## KVFR Prevention SEPA Comments

Project: Nunnally Project  
Permit#: SE-21-00006  
Date: 06/06/2022

Re: SEPA Register 202202640, SE-21-00006

Thank you for the opportunity to comment on the Mitigated Determination of Non Significance for the Manastash Estates private access roads, proposed by Nunnally Holdings, LLC We have reviewed the environmental checklist and have the following comments.

DRAWING NO. **C1.9**
PROJECT NO. **20.010**
DATE: **11/23/20**
SHEET NO. **10 OF 10**

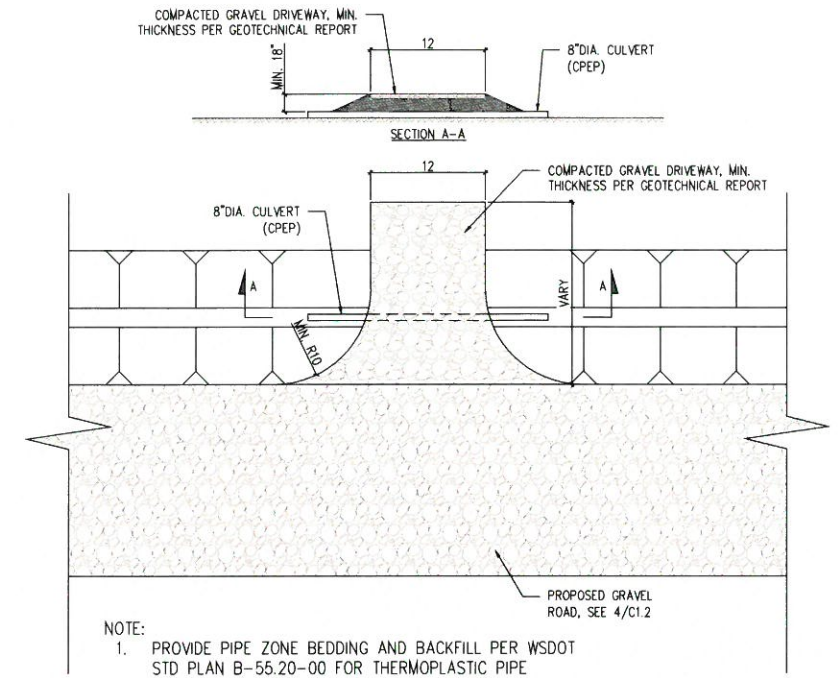
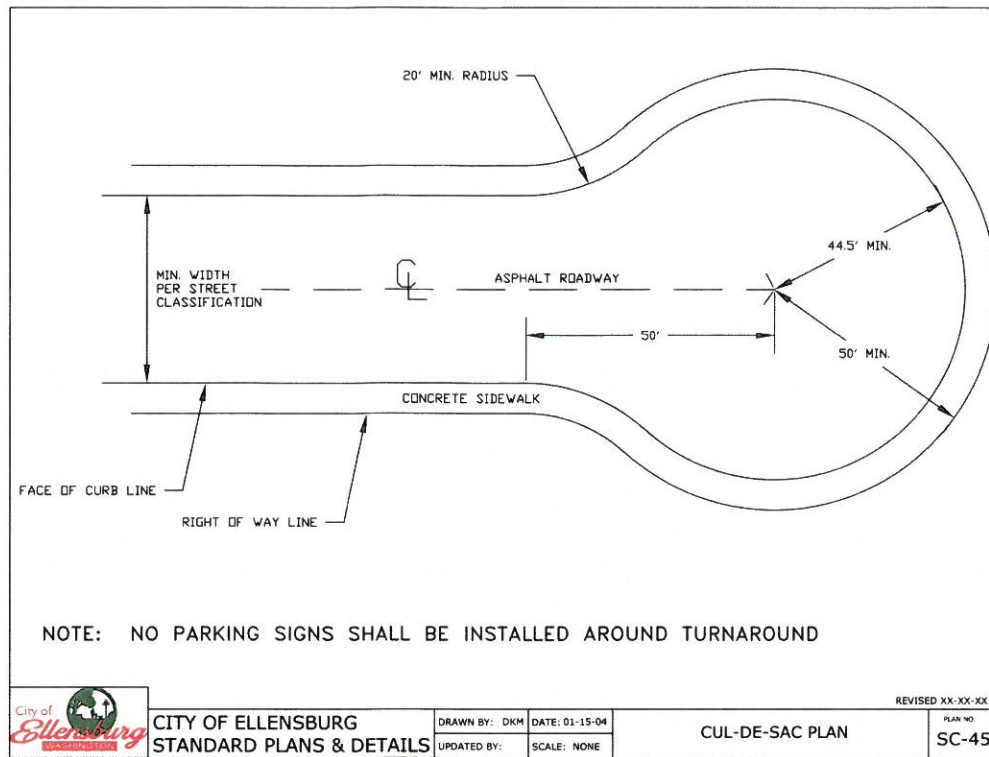
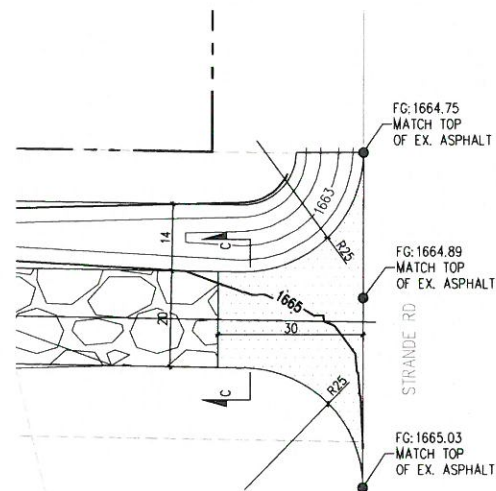
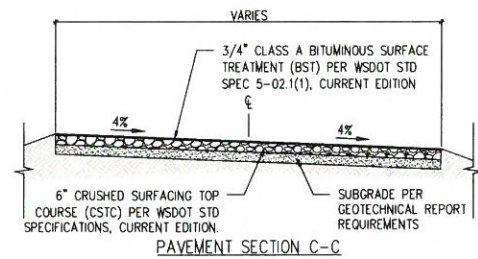
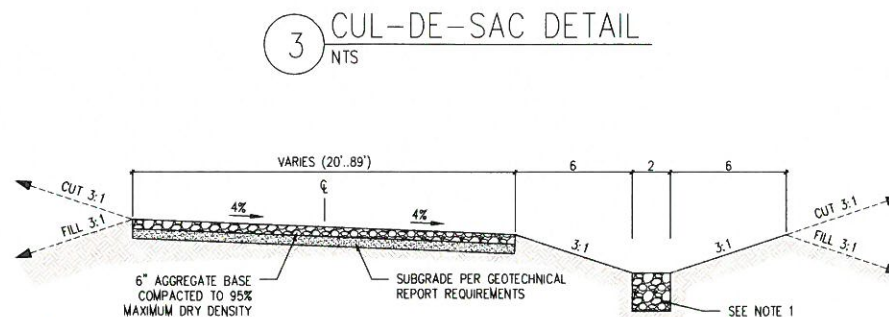
- Fire apparatus access roads exceeding 150' shall be provided with a temporary or permanent turnaround meeting the requirement 2018 IFC Appendix D.
- Fire apparatus access roads shall not exceed 10% in grade. This is especially critical in our valley's climate.
- The IFC Appendix D requires the road be a minimum of 20' wide and capable of supporting an imposed load of at least 75,000 lbs.
- Our standard turning radius is a minimum of 23' inside and 45' outside.
- Water supply meeting Kittitas County requirements.
